Department of Planning and Environment
4 Parramatta Square, 12 Darcy Street
Parramatta NSW 2124

**COUNCIL SUBMISSION
NOTICE OF EXHIBITION OF MODIFICATION REPORT NO. 1 FOR THE PARRAMATTA
POWERHOUSE (30B PHILLIP ST, PARRAMATTA)**

I refer to the above application and the request to provide advice on the proponent's modification report to the St Georges Terraces and eastern rooftop. Council has reviewed the supplied report and wish to make the following comments:

1  
1 : 100  
PROPOSED PLAN - GROUND FLOOR

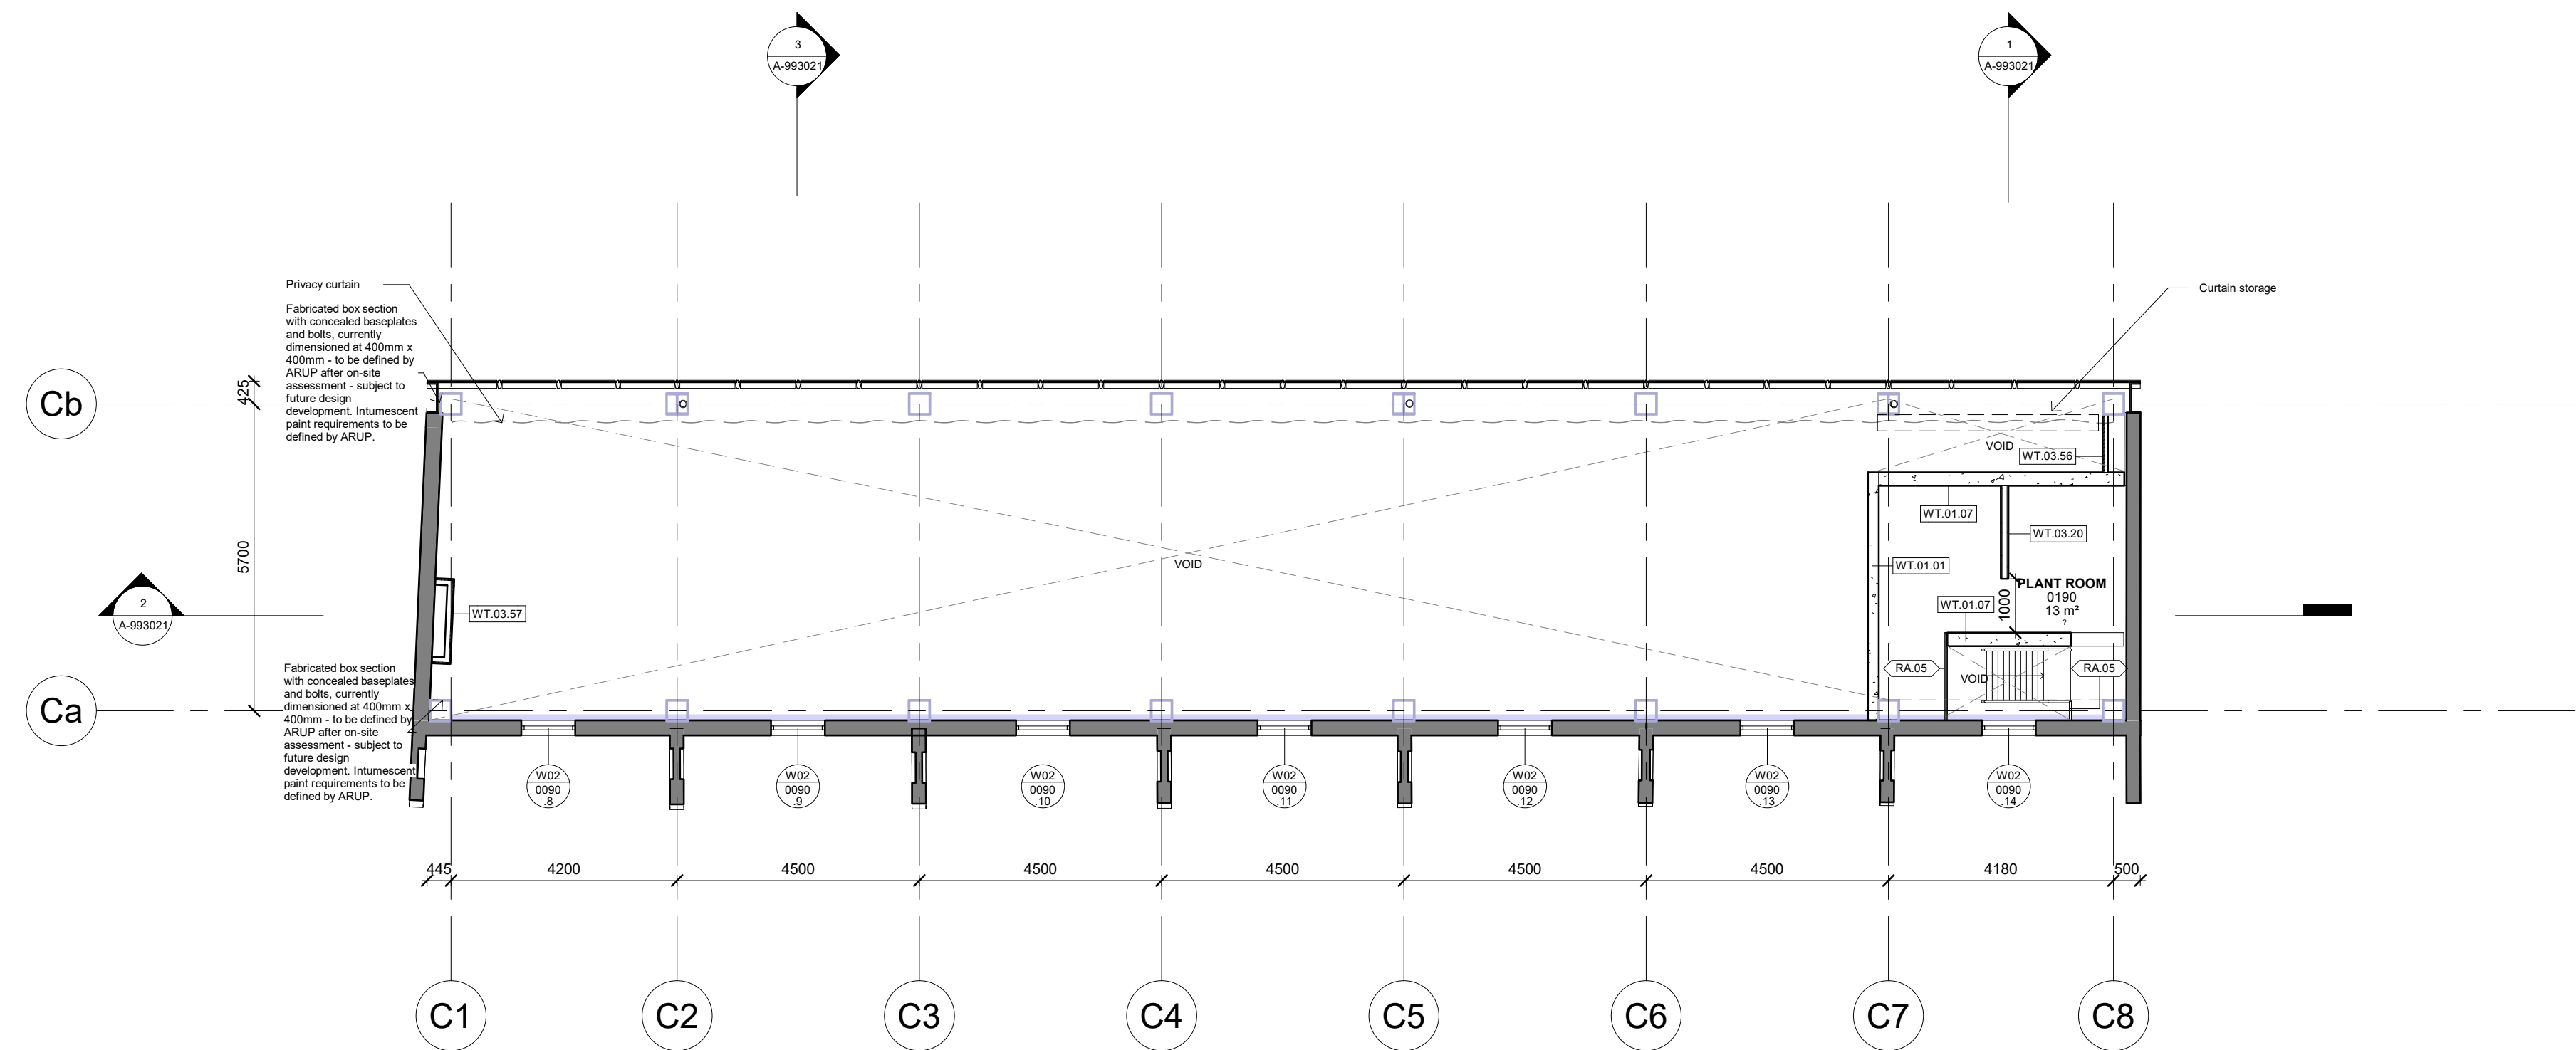
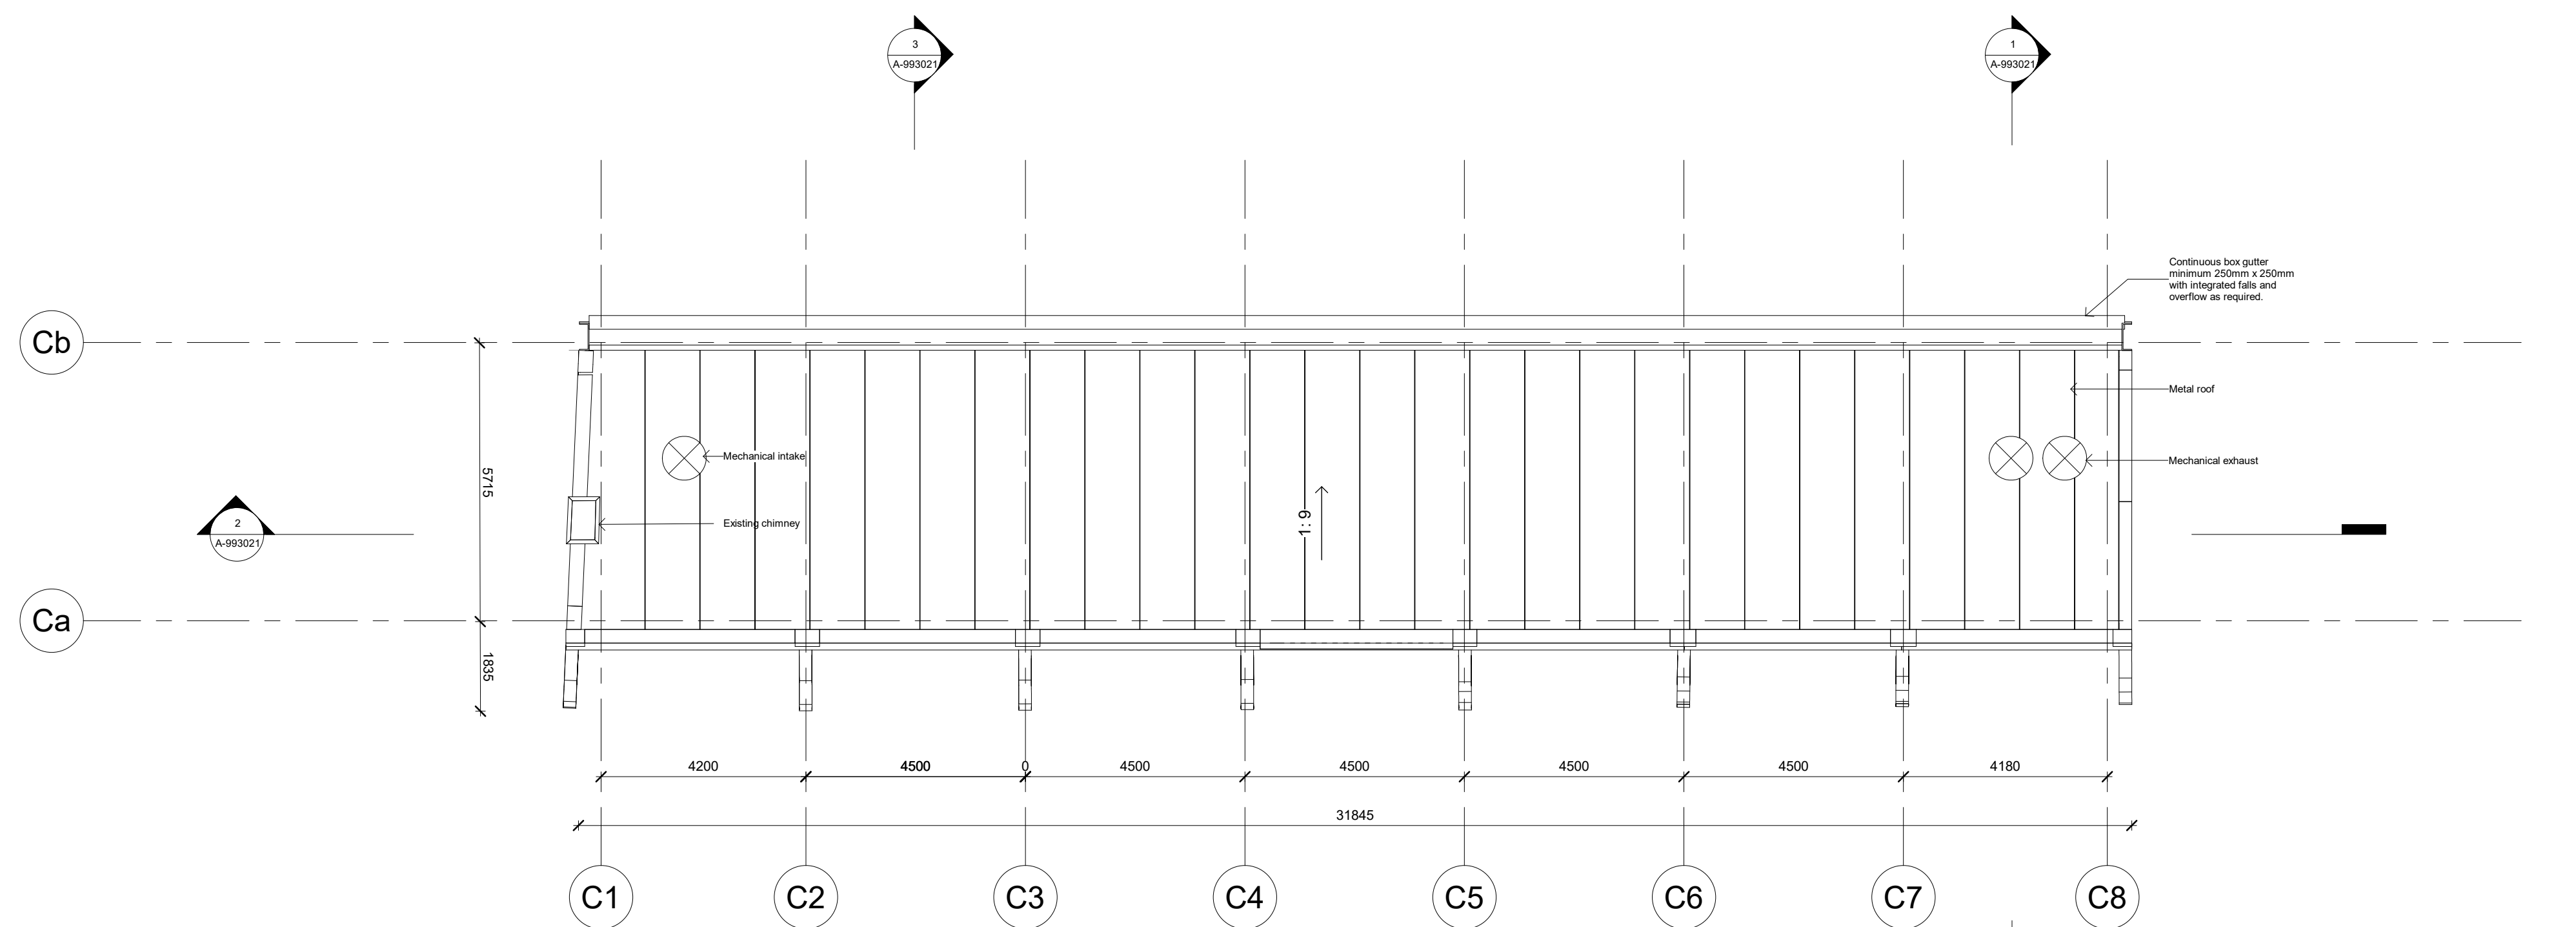
1. The retention and restoration of some of the existing chimneys. The remaining internal fabric includes modest fireplaces and potentially some internal walls that are evidence of history and use which contribute to the heritage significance of St George's Terrace.

2. The window and door openings should be reinstated to the original proportions, including the removal of the brick window infills.
3. Fill or reconstruct the additional opening spaces at ground level that were created to convert each terrace into a commercial business with shop front incorporating door (between 1970 and 1978). This should be based on historical evidence if any and the use of sympathetic materials compatible with the building's heritage value is recommended.

4. The reinstatement and restoration of the first-floor verandahs. The statement of heritage significance states that *"Original verandahs with curved corrugated iron*
